CITY OF PORTLAND

DEPARTMENT OF PLANNING & URBAN DEVELOPMENT
INSPECTION SERVICES DIVISION

LOCATION: 35-37 Tate Street

HOUSING INSPECTION REPORT

Proposed Apt 2

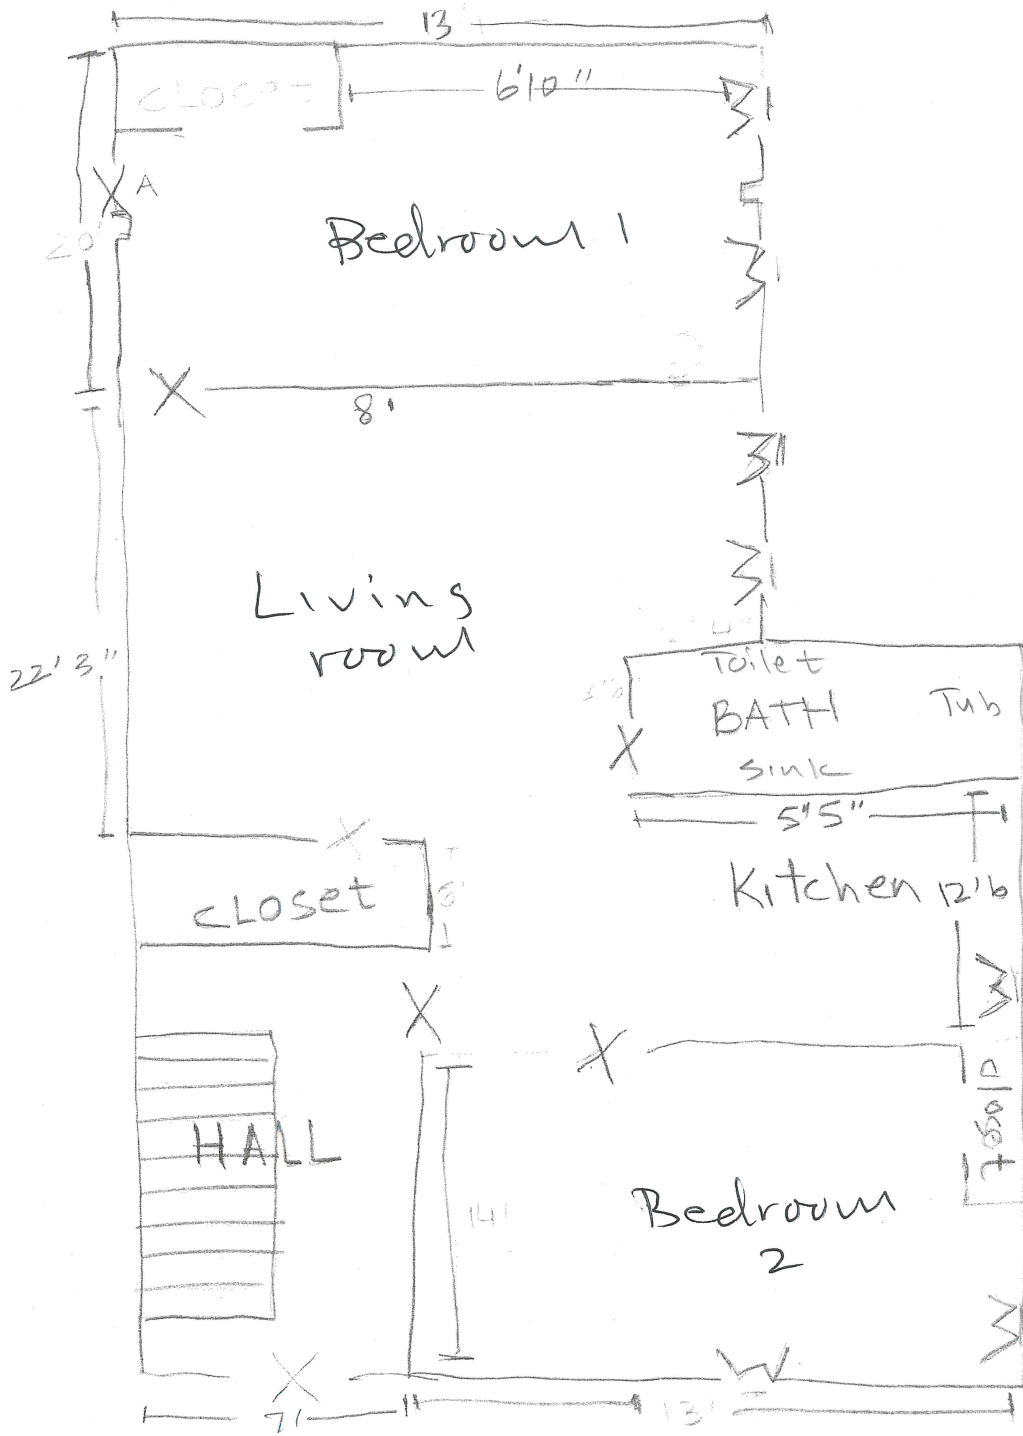
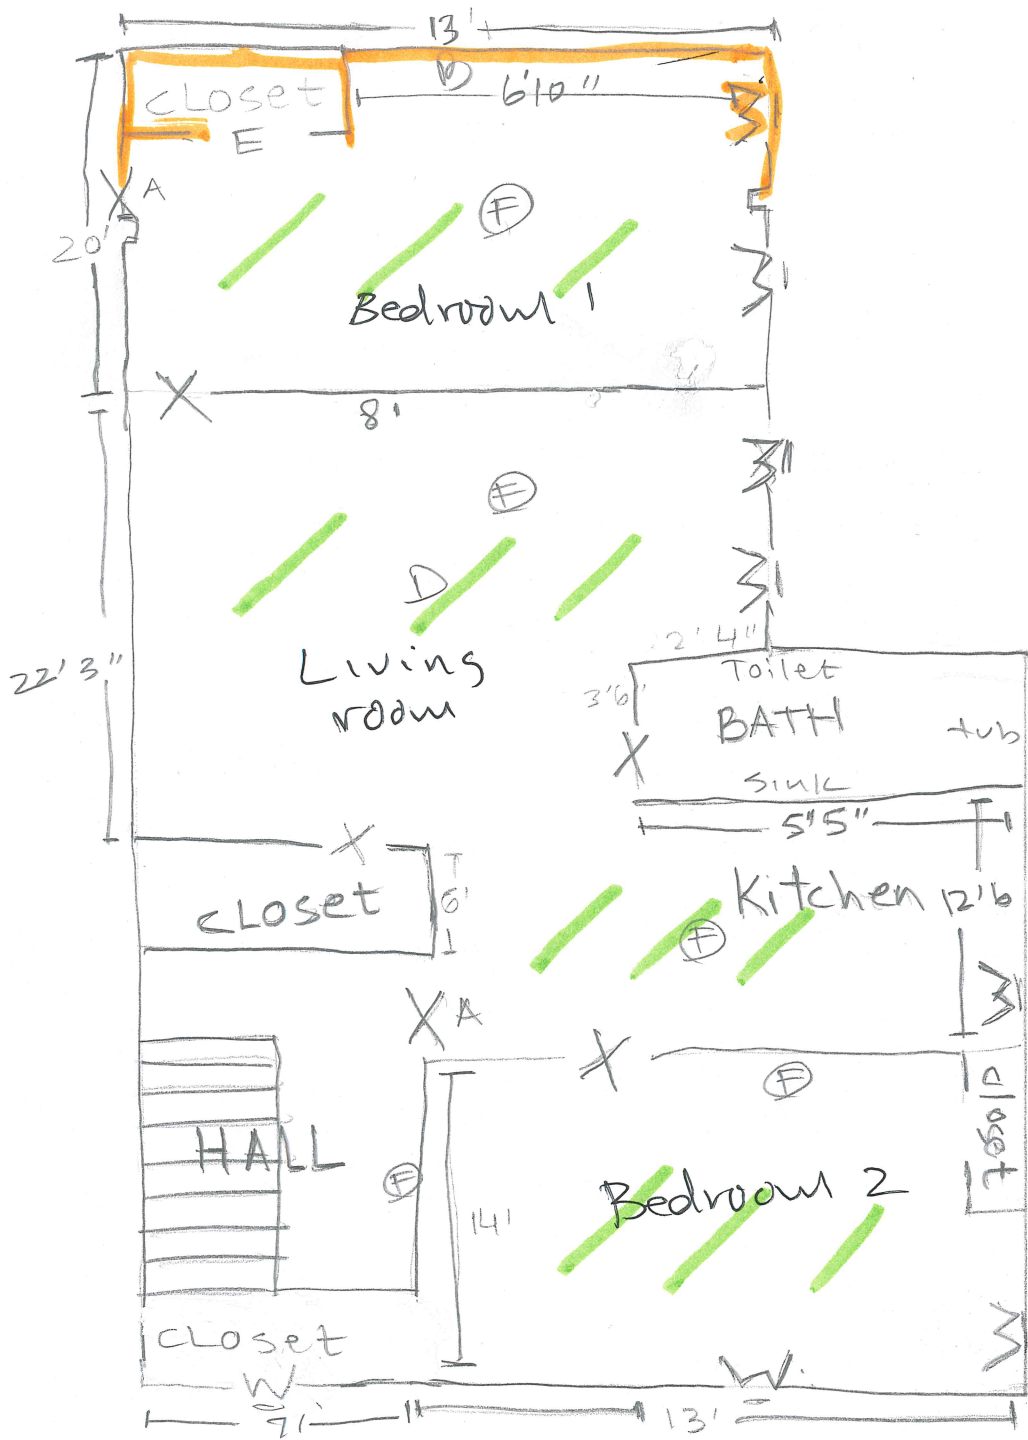
4. INTERIOR LEFT & RIGHT - cellar - missing lally column.	108-2
* 5. INTERIOR SECOND FLOOR RIGHT, APT. #2 - living room - window - broken glass.	108-3
6. INTERIOR SECOND FLOOR RIGHT - APT. #2 - kitchen window - broken sash.	108-3

7. INTERIOR SECOND FLOOR RIGHT, APT. #2 - kitchen window - missing stop.	108-3
* 8. INTERIOR SECOND FLOOR RIGHT, APT. #2 - lack of egress.	116-2
9. INTERIOR RIGHT FRONT HALL - hanging Romex.	113-5

17. EXTERIOR SECOND FLOOR LEFT, APT. #2 - kitchen & bathroom - missing storm windows and screens.	108-2
18. ✓ INTERIOR SECOND FLOOR LEFT, APT. #2 - living room & bathroom - missing counterbalance cords on windows.	108-3

* 19. ✓ INTERIOR SECOND FLOOR LEFT, APT. #2 - living room & store room - broken glass.	108-3
* 20. INTERIOR SECOND FLOOR LEFT - store room - frayed ceiling light.	113-2

* 21. ✓ INTERIOR LEFT FRONT - cellar - hanging ceiling light.	113-5
22. INTERIOR SECOND FLOOR LEFT REAR, APT. #2 - kitchen - hole in floor.	108-2
23. INTERIOR SECOND FLOOR LEFT REAR, APT. #2 - bathroom - lack of ventilation.	108-3

HALL 2nd Floor

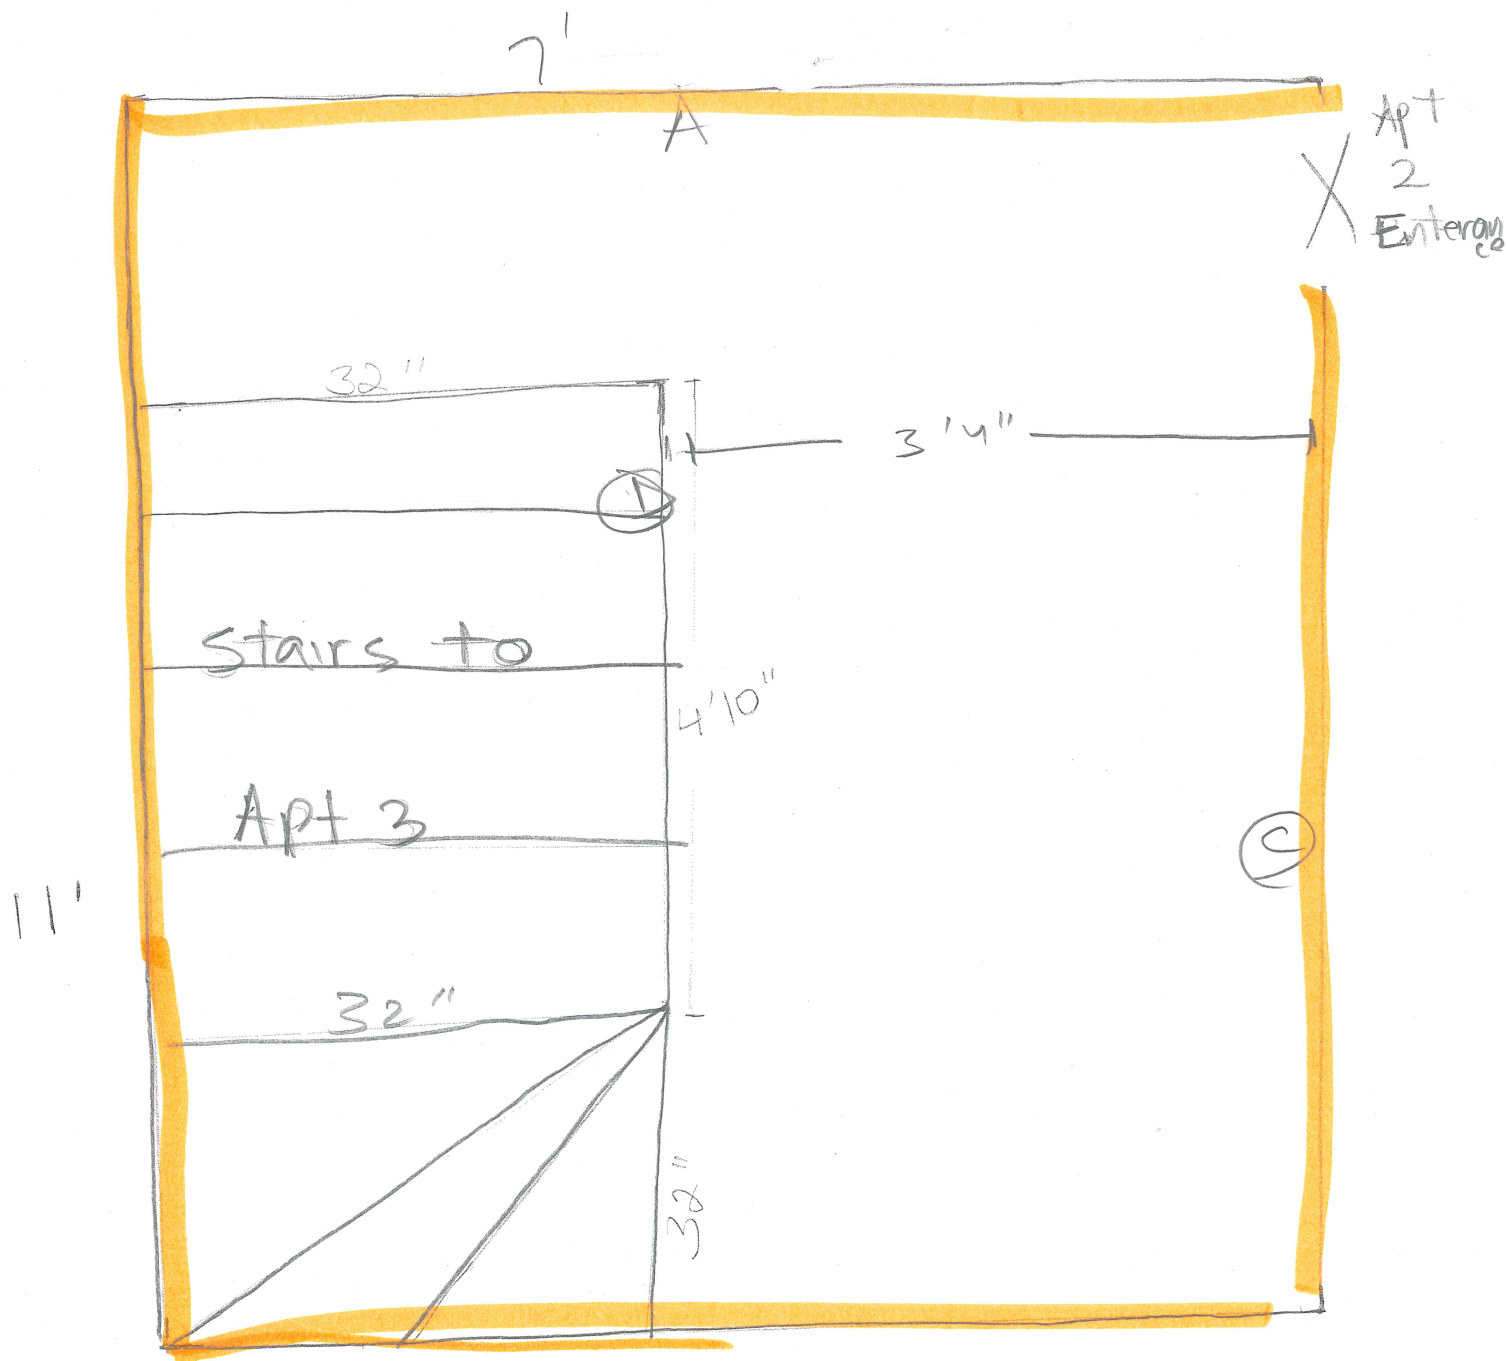
* 12. INTERIOR SECOND FLOOR RIGHT REAR, APT. #4 - lack of egress.	116-2
13. SECOND FLOOR - front hall - broken and missing railings.	108-4
* 14. INTERIOR SECOND FLOOR REAR - hall ceiling - missing plaster.	108-2
